Hearing Transcript

Project:	Rosefield Solar Farm
Hearing:	Recording of issue specific hearing 3 (ISH 3) - Part 4
Date:	07 July 2026

Figure A.4: Receptors within the 1km study area (**WEST** section)

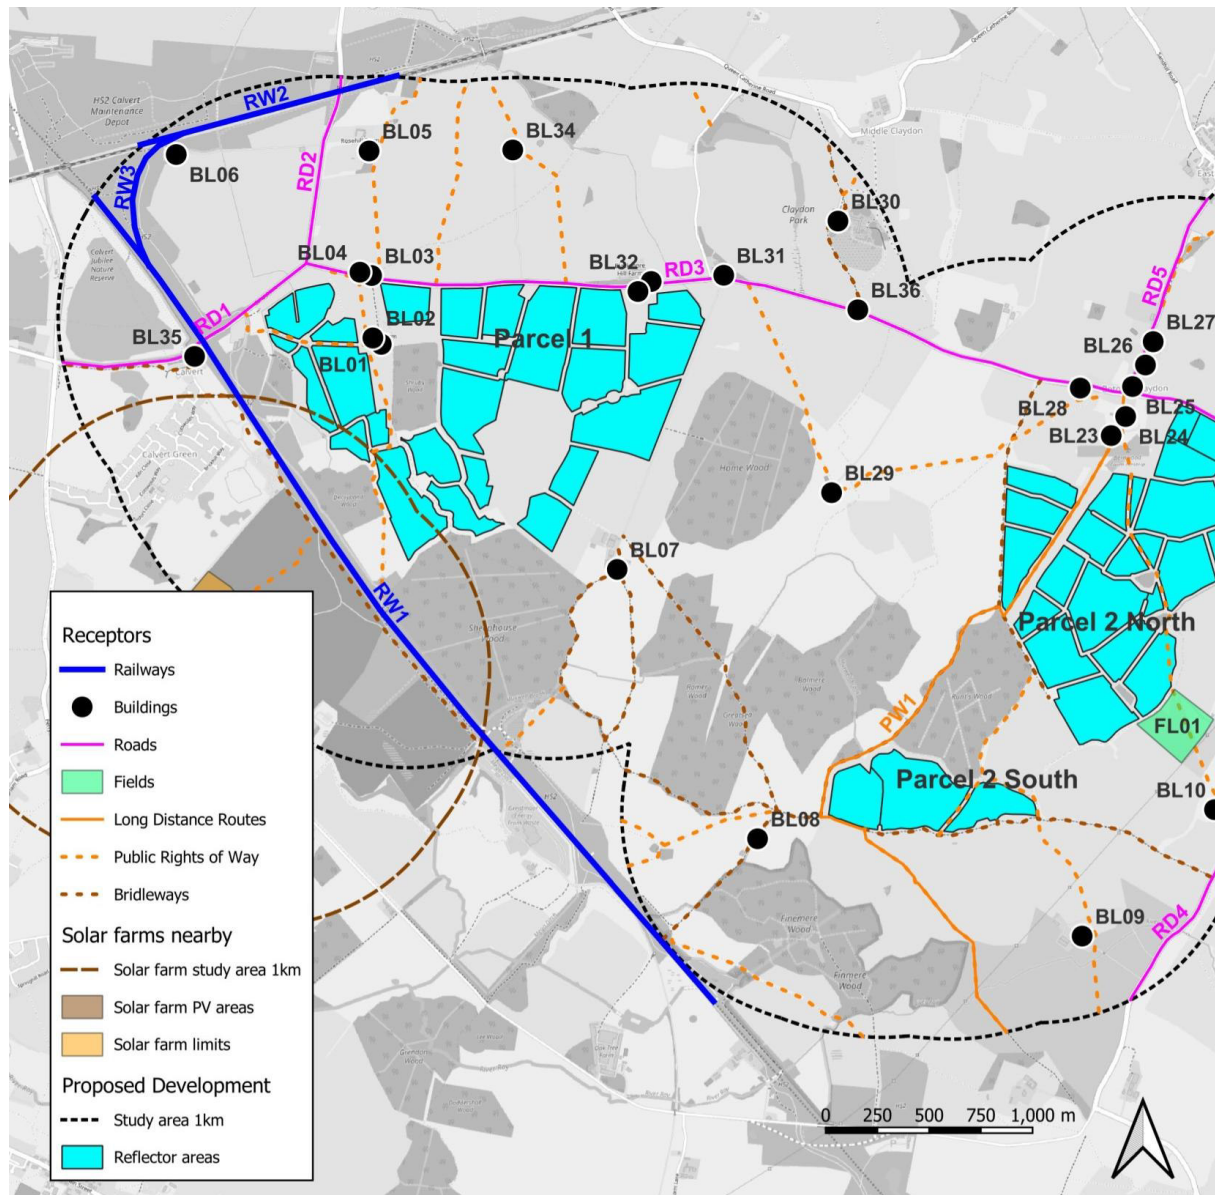
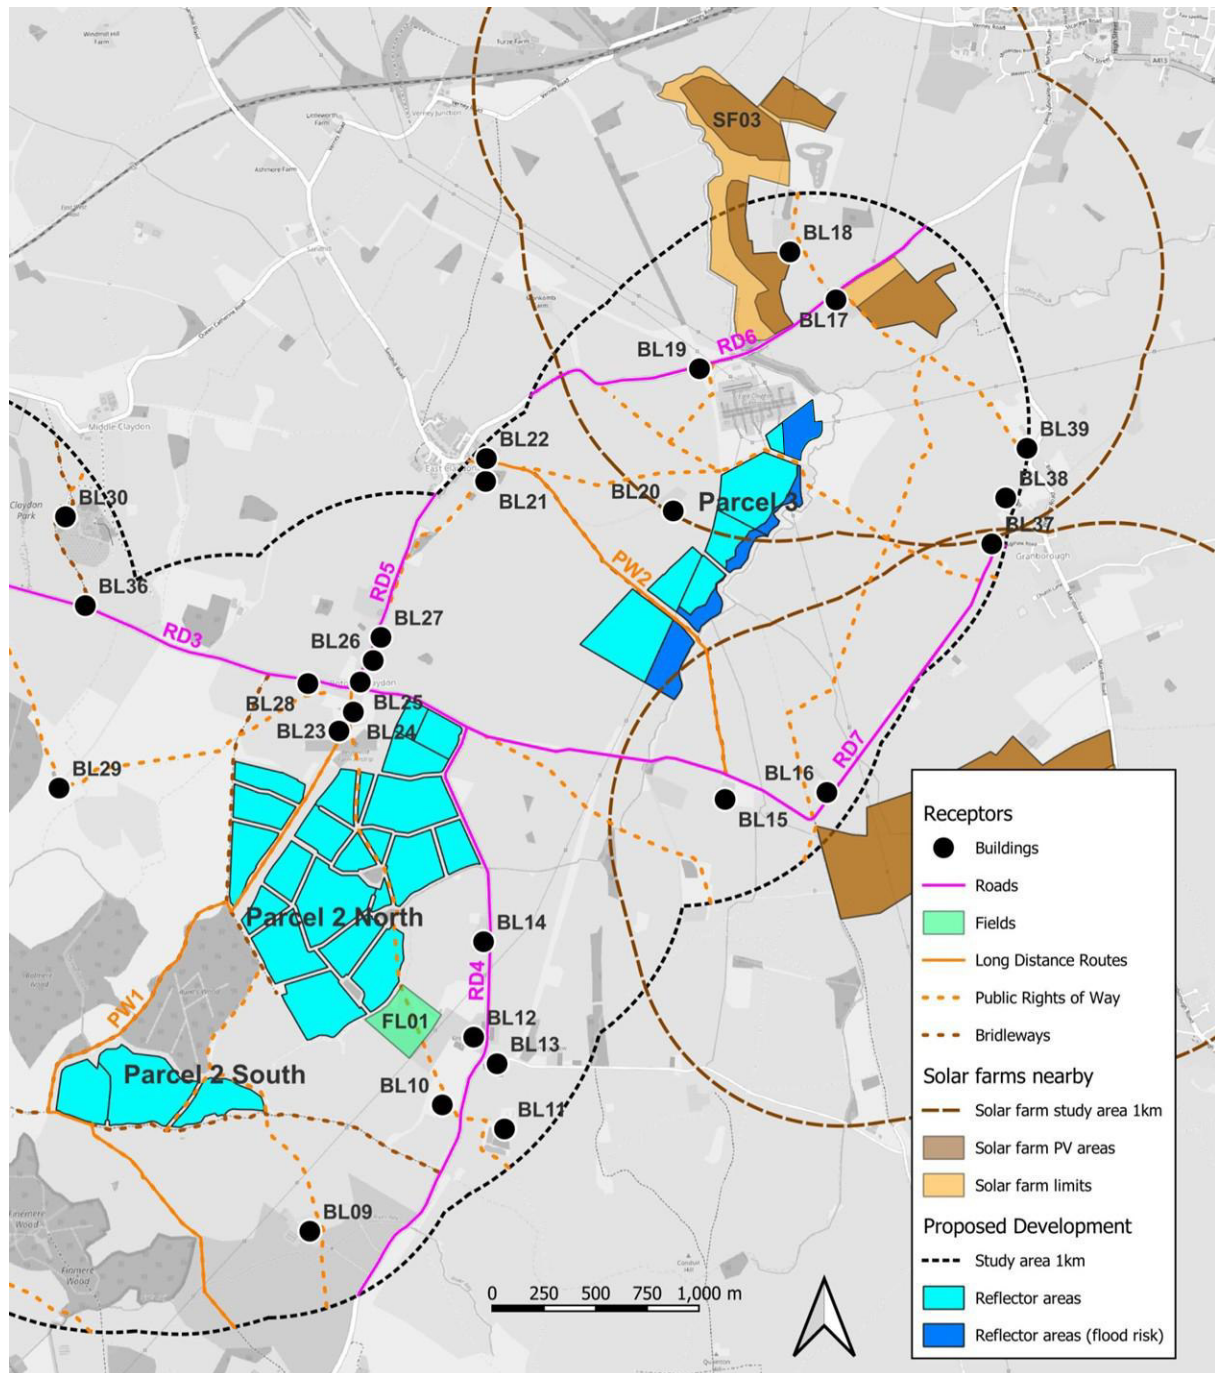
I beg your council's response to our further written questions. Q 2.1.1 that's lib reference rep 4094 and notes that paragraph 6.3.1 of the applicants glinting glare assessments. And that's lib reference app dash 082 would appear to imply that local roads are low sensitivity receptors,

and if so, it seeks further clarification of this given potential road safety concerns. The council has also requested the submission by the applicant of the solar voltaic building developments glint and Glare guidance from 2022, which is referenced in the glinting glare assessment as well as that informs the basis for the significance of effects criteria, potentially. Question. First of all, is the applicant have local roads been assumed to be low sensitivity in the Glen Sinclair assessment?

Thank you, Sir. Daniel Gazelka for Buckinghamshire Council. I've, I've spoken to our, um our traffic expert on this as well, Mr. Duncan, who was on the line as well. Um, I think where this concern came from was, was primarily because we thought 6.3.1 said that, um, and it would appear that it does. Um, our view would be that that is a low by which I mean appears to be quite a low assessment of sensitivity for what is vehicular traffic on a road which will be traveling, you know, at speeds depending on if it's a national speed limit, 30 to 60 miles an hour.

Um, we consider that there should be an assessment of the actual roads that are affected here. Um, considering whether that is a conclusion that can be come to with the roads here, I should say, when it's been referred to as guidance page power, are experts who do lots of these applications. You may have seen them in other schemes if you've looked at the applications. Um, but it's not government issued guidance or anything of that nature. It's just what page of power as a private entity have published as the guidance that they use? Um, our concern ultimately is that this assesses the sensitivity of local roads to low my understanding.

Thanks, sir. Carly Tinkler of Clayton Solar Action Group. Um, yes, I think you understand. Clayton Solar Action Group's position on Glint and Glare. One, two points that I'd like to make about effects on the roads is to bear in mind. And I don't believe that the glint and glare assessment has considered that, unlike motorways and dual carriageways, these minor roads and lanes are used by people for recreational purposes because they're quite quiet, and therefore our concern is that the effects of glint and glare would not only potentially result in a crash, but it could also affect people using the roads, on bicycles, on foot and on horseback.

And the other point that I don't believe that the glint and glare assessment has considered is that when people are driving along the local roads, they haven't considered the sequential effects of of the glint and glare, in other words. I understand that they have assessed it from from a certain point, but in fact, as people are travelling around, they could experience it multiply and often not expect it. You know, I think the argument in the informal method is that people can move away from the effect, or they they will know that because the sun is low in the sky, that there's more likely to be an effect of glinting glare.

Yeah. Ian Foley, on behalf of the applicant, as I stated, the the guidance on solar Caltex and Linden Blair, it's fairly clear that local roads are to be treated as low sensitivity and that the highest significance would be low and therefore mitigation is not required for for effects as a result of that. Now just I guess to elaborate on that and give a little more detail, I guess the the guidance is not particularly specific on the reasoning as to why it's low significance, other than local roads tend to be, uh, or have slower speed limits and contain less traffic.

We've done some work in preparation for this hearing to confirm that, but I appreciate that isn't currently before the examination. So we can submit that along with our speaking not at deadline five. Um, maybe that's not the best place, but we'll think of a better place perhaps for deadline five, but that more granular analysis has been carried out in preparation for today and the result is the same, notwithstanding the guidance.

On behalf of the applicant. We we've conducted and actually the the text before you um, prepared last night is actually an extension of the text that's included within the original report. So it is detailed commentary on each of the receptors, each of the local roads within the area, within the study area. Um, whilst we still categorize the significance of those roads as low, the conclusion would be low or no significant effect, even if they were of moderate or high sensitivity.

On behalf of the applicant. The, um our assessment does consider, uh, multiple viewing points. So it does consider the kind of progress of vehicles along the road. Um, whilst the. I guess the main point of the assessment is to consider impact upon drivers. Um, the the same considerations would be given to cyclists or those on horseback, albeit they may be at slightly different heights. But our assessment does consider, uh, drivers of carts, which I would imagine are a similar height to cyclists and drivers of HGVs, which would be probably, uh, similar height to um, users of horses.

Yes. Ian, on behalf of the applicant, we, uh, we do consider the, um, the implications, although at this point, qualitatively, qualitatively only. We do consider the implications of each parcel of PV panels. So we look at each one in isolation. And then the implications for each of those parcels upon each receptor. So if there were going to be combined effects we would consider that at this stage.
